**KIRKLEES METROPOLITAN COUNCIL
INVESTMENT & REGENERATION SERVICE**

**DELEGATED DECISION TO DETERMINE APPLICATIONS FOR
CONSENT, AGREEMENT OR APPROVAL REQUIRED BY CONDITION**

Reference No:	2025/44/92676/W
Site Address:	Part of former St Luke's Hospital site, Blackmoorfoot Road, Crosland Moor, Huddersfield, HD4 5RA
Description:	Discharge of details reserved by conditions 12 (retaining walls), 17 (carbon emissions), 18 (crime mitigation strategy), 20 (noise assessment), 21 (materials), 23 (boundary treatments) and 32 (delivery noise management plan) of previous permission 2023/91405 for erection of foodstore (Class E) with associated access, parking, servicing area and landscaping
Recommending Officer:	Ellie Thornhill

Officer report

PROPOSED STONE RETAINING WALL WITH ASHLAR STONE CAPPING FINISH (TO STUCTURAL ENGINEER DESIGN AND DETAILS) WITH 1100MM METAL FENCE/GUARDING ON TOP. (RETAINING WALL HEIGHT VARIES)

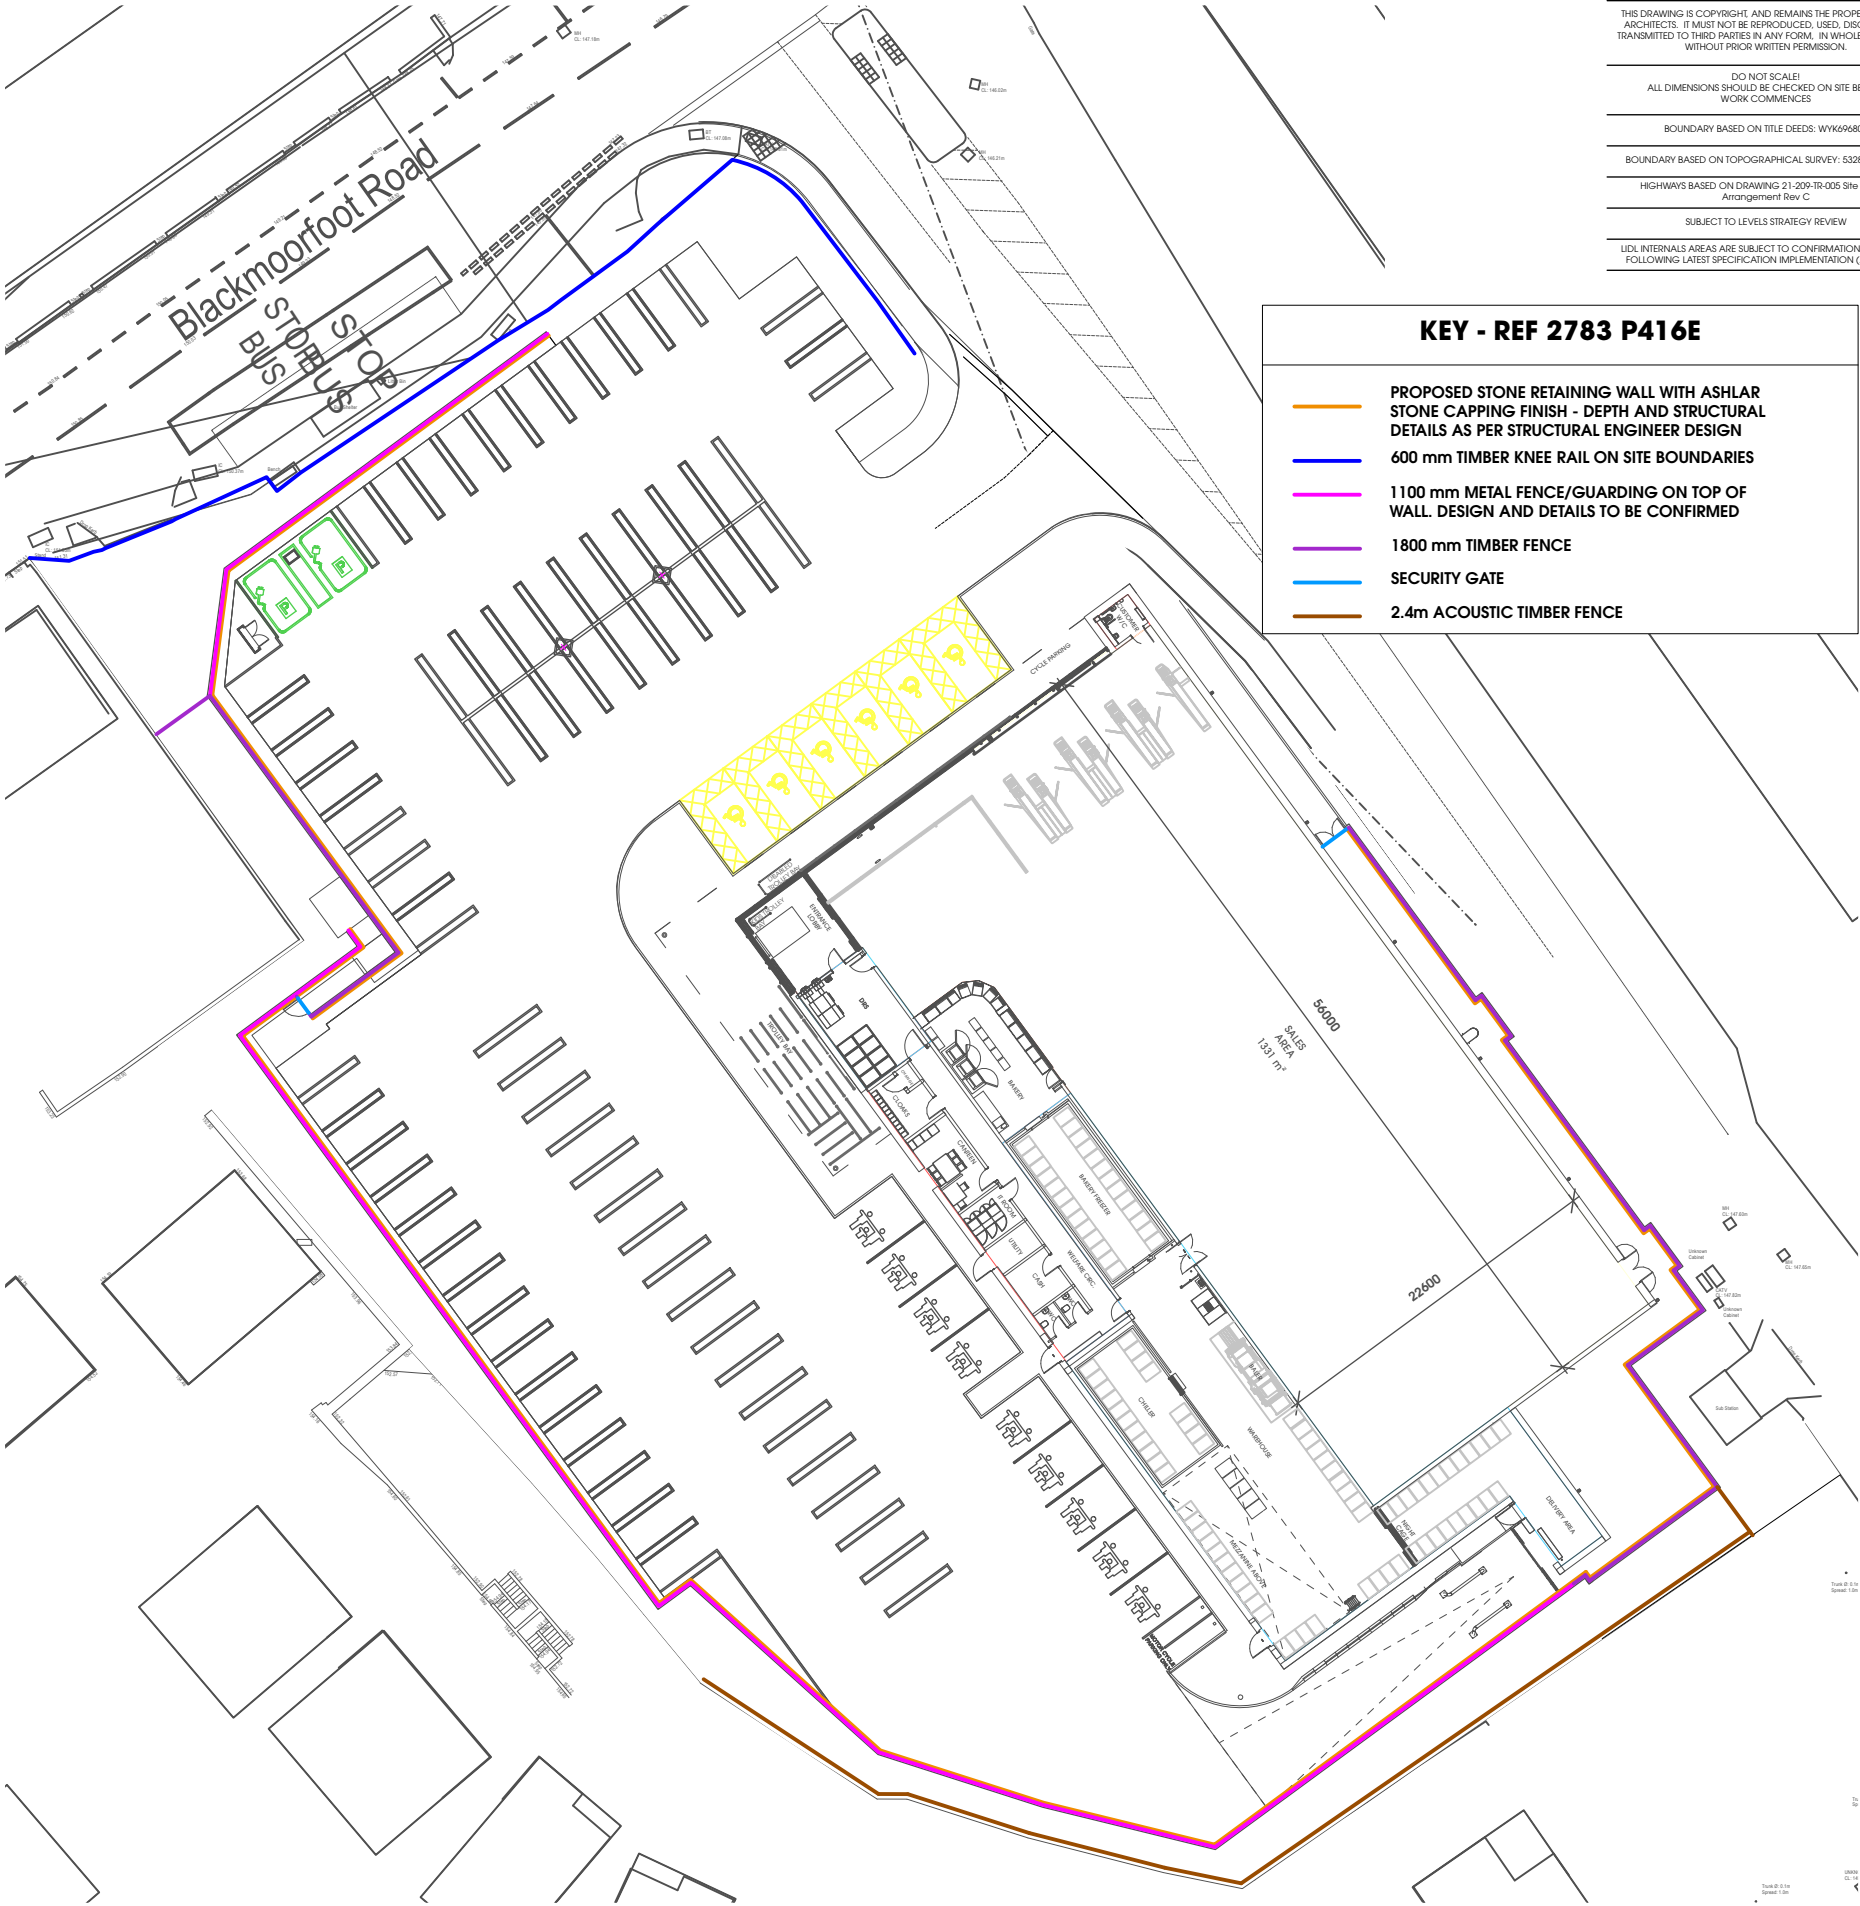
I would like to advise that planning Condition 12 (retaining walls) cannot be discharged pending the formal technical approval of the design of proposed retaining walls adjacent to the existing highway (via the submission of an AIP: Approval In Principle).

The submitted information is considered insufficient to demonstrate compliance with the technical requirements of Condition 12. This aligns with the latest comments from the Highways Structures Team, who concur that the information submitted is insufficient to discharge Condition 12.

Therefore, in the absence of sufficient detailed information and the corresponding review, in order to assess the structural integrity of the proposed

retaining wall adjacent to the highway, along with its design and materials, it has not been demonstrated that the details would secure the safe and efficient operation of the highway. As such officers are unable to recommend that the submitted details be approved.

The latest comments from the Highways Structures Team are that the information submitted is insufficient to discharge Condition 12. Therefore, in order to assess the structural integrity of the proposed retaining wall adjacent

to the highway, along with its design and materials, a technical report is required.

As such, this condition cannot be discharged at this time.
